Consultant Response to Drainage Comments

D1623 - FORMER CHANDLERS BMW, WATER LANE, ANGMERING

Engineers Comments Regarding Surface Water Drainage:

| Date  | March 2019 | Drawing No. | 2018-D1620-PL400 | Rev        |    |          |    |

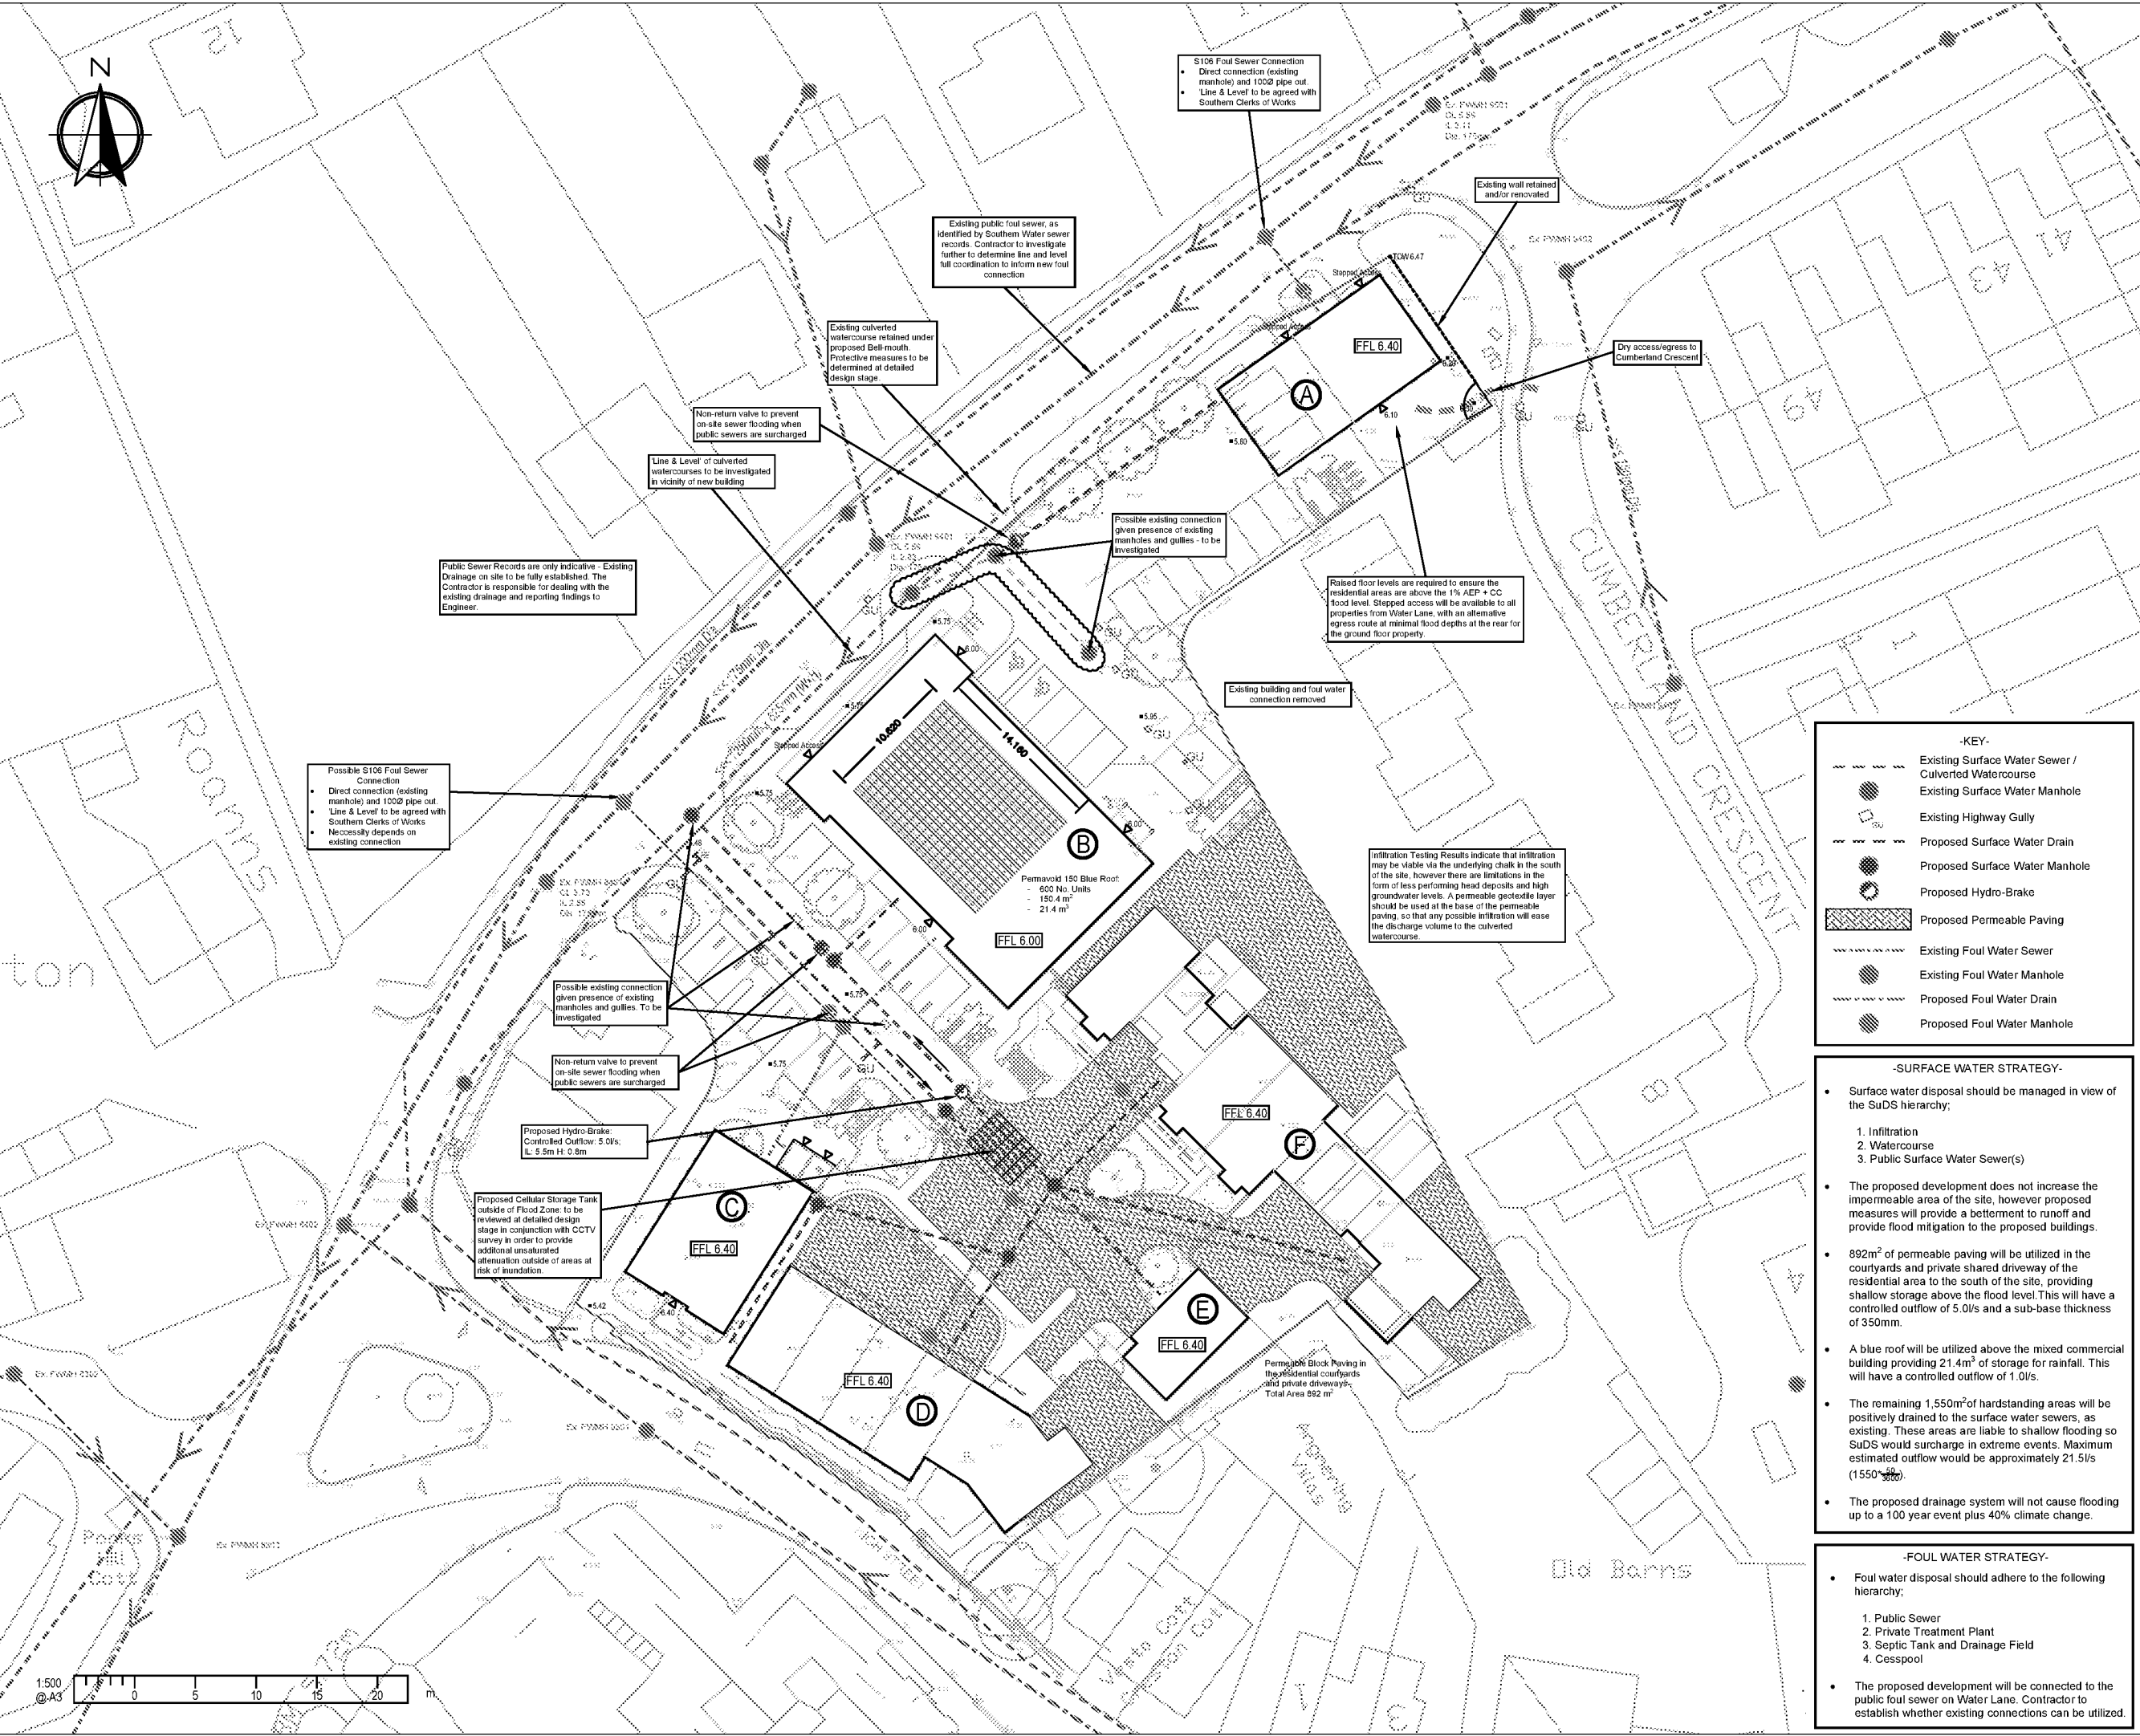
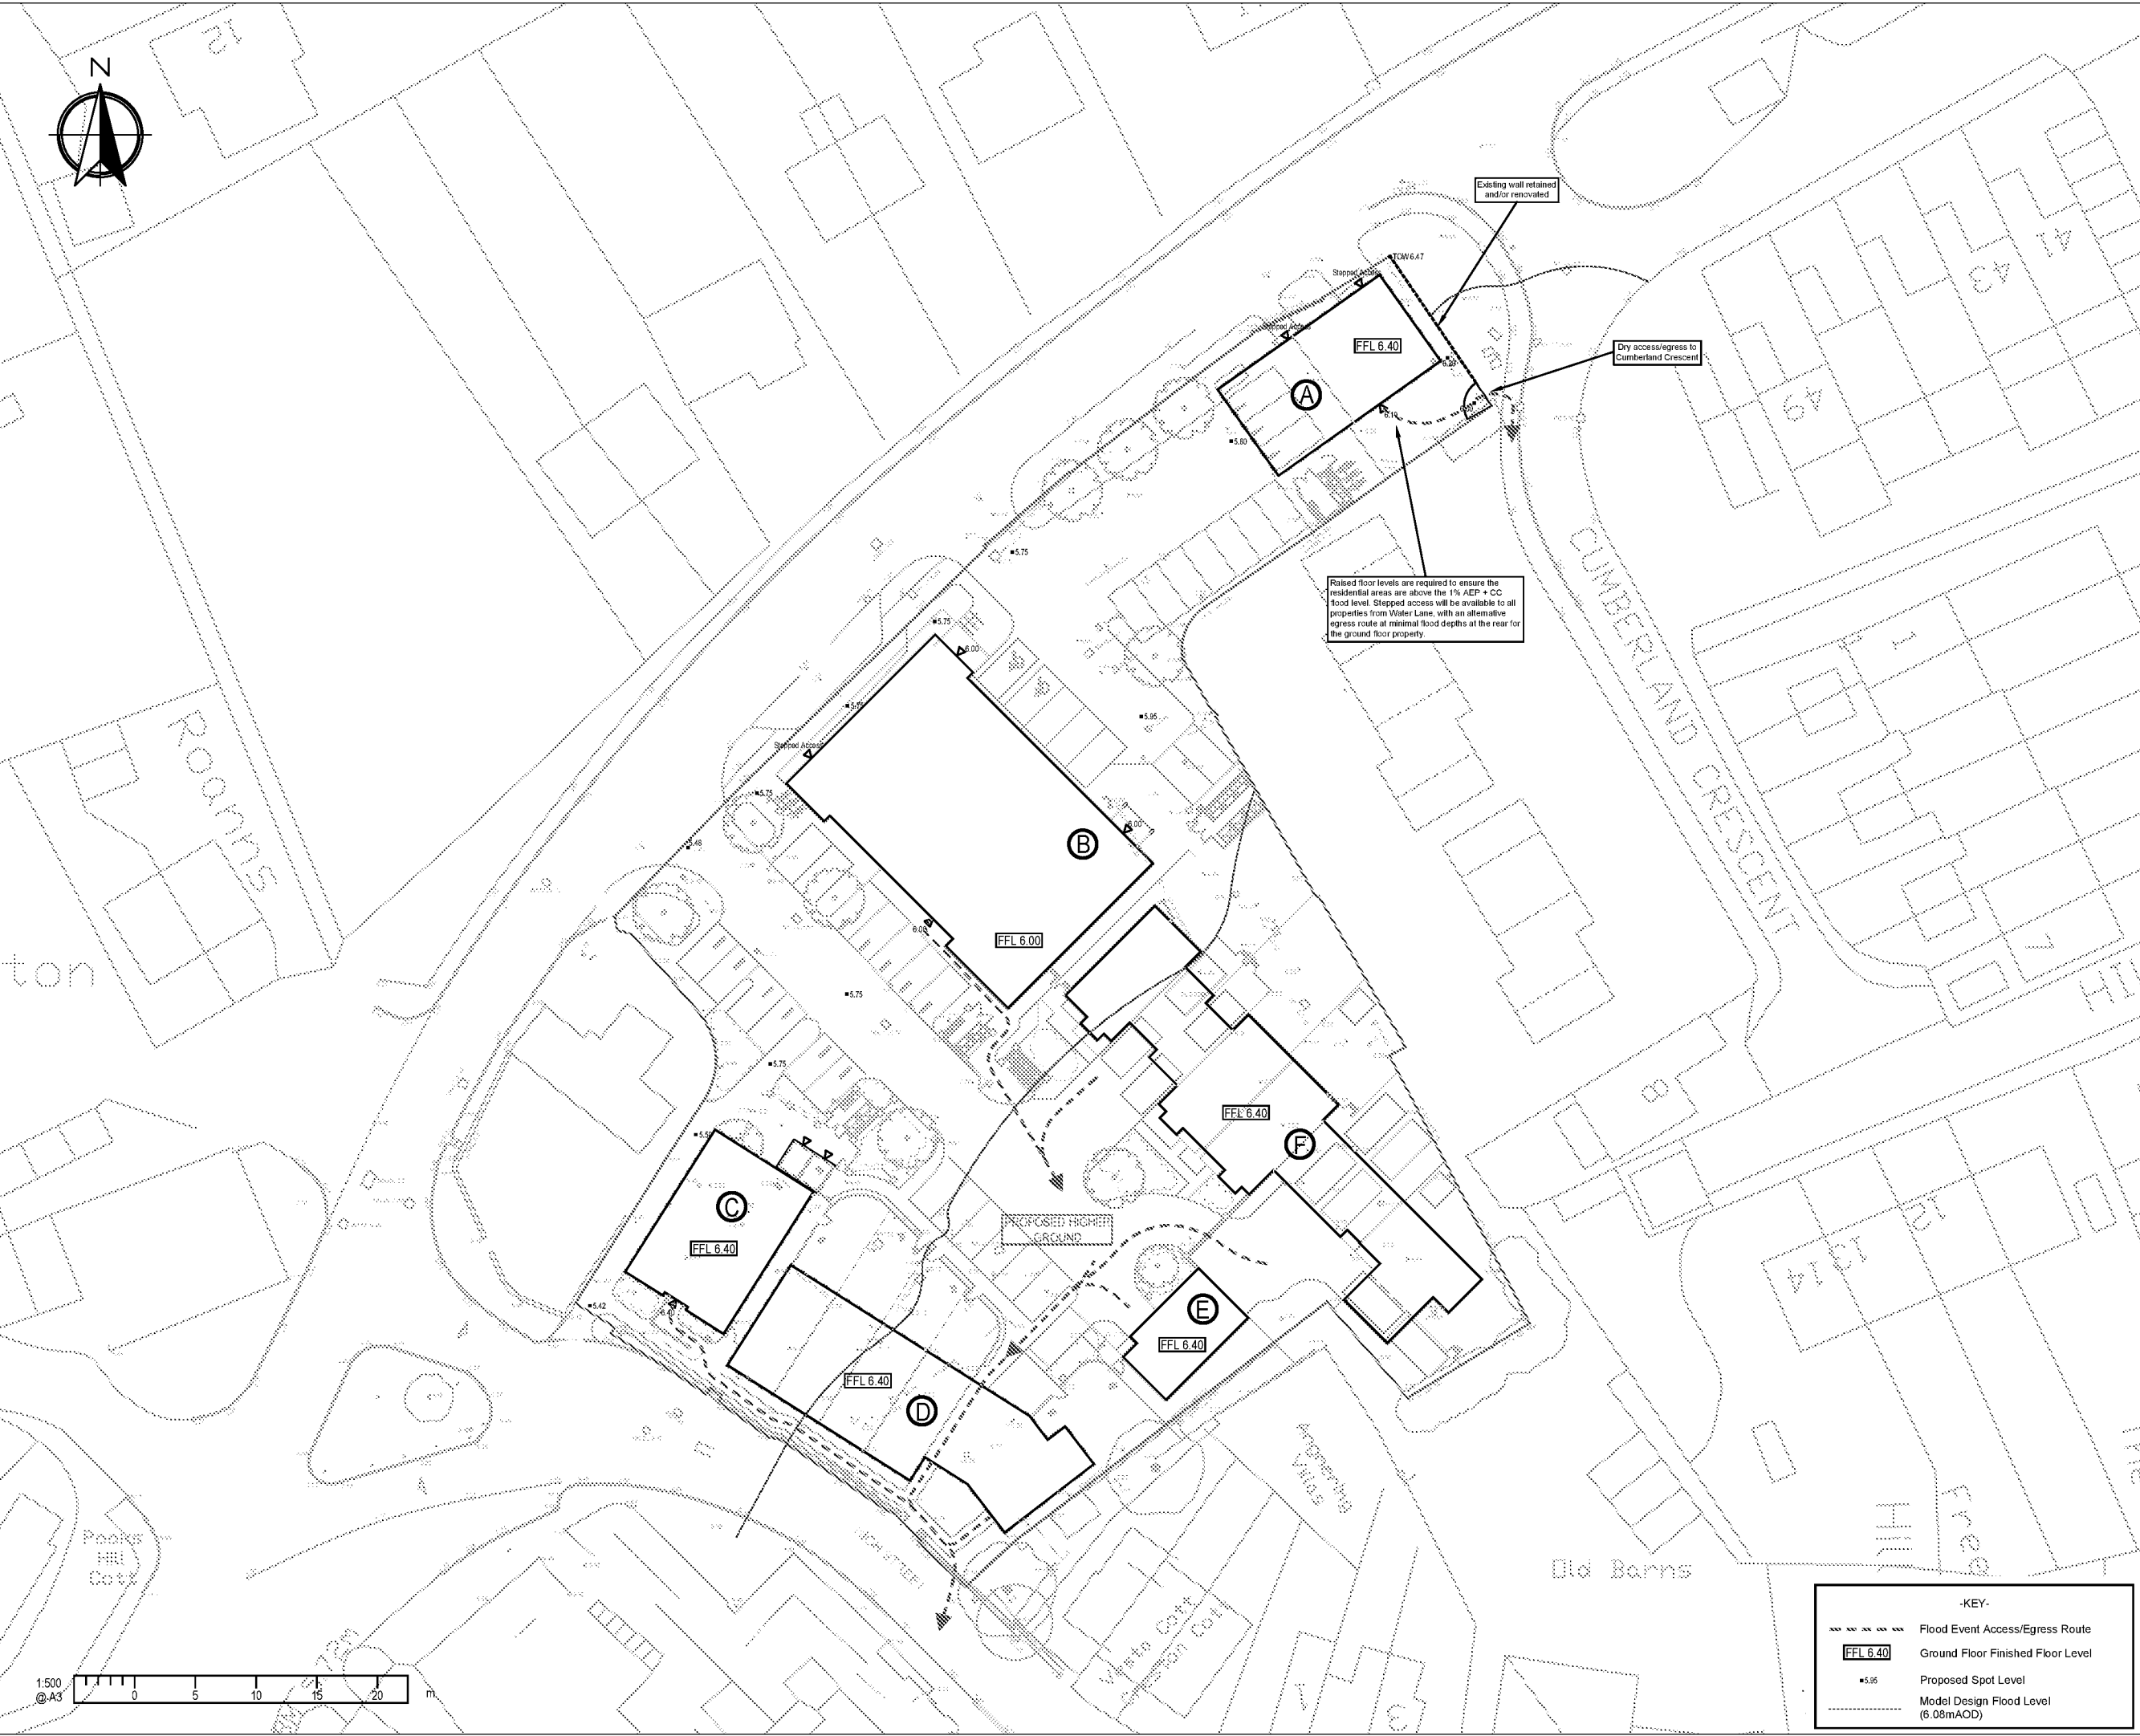
It is not clear from the detail submitted if the attenuated volume can be contained on site outside of the predicted flood extents. I.e. it has not been demonstrated that the proposals will not increase flood risk and the development can be adequately drained. A layout plan of the proposed surface water drainage scheme needs to be submitted, with further refined calculations. This information needs to be submitted before determination of the application. **Therefore, I currently object to the proposal.** Once further detail has been supplied by the applicant please re-consult.

The provided report, drawings and calculations clearly demonstrate the required volume to be attenuated on site and the proposals for ensuring this occurs at a minimal discharge rate without flooding to the site up to the design flood event. DWG PL400 demonstrates a layout plan of the proposed surface water drainage scheme, and Appendix G demonstrates clear calculations showing Qbar and flood mitigation up to the design flood event.

The submitted FRA details that some of the existing drainage arrangement will be utilised. Given the high risk of flooding in the area we would be looking to obtain improvement from the proposals, in line with WSCC policy we require proposed discharge rates to be as close to greenfield QBar as possible. Any proposals to alter or provide additional connections to the culverted main river would require a flood risk activity permit from the Environment Agency.

The proposed strategy has provided attenuation as far as possible outside of the flood extents via a variety of sustainable drainage measures, in order to reduce discharge into the watercourse. The existing site is hardstanding, with no SuDS and direct uncontrolled flow into the watercourse. The proposals dramatically reduce runoff to the watercourse in all areas as demonstrated in the report and the calculations provided, other than Building 'A' (as labelled on DWG PL400) where no sustainable drainage measures are deemed appropriate.
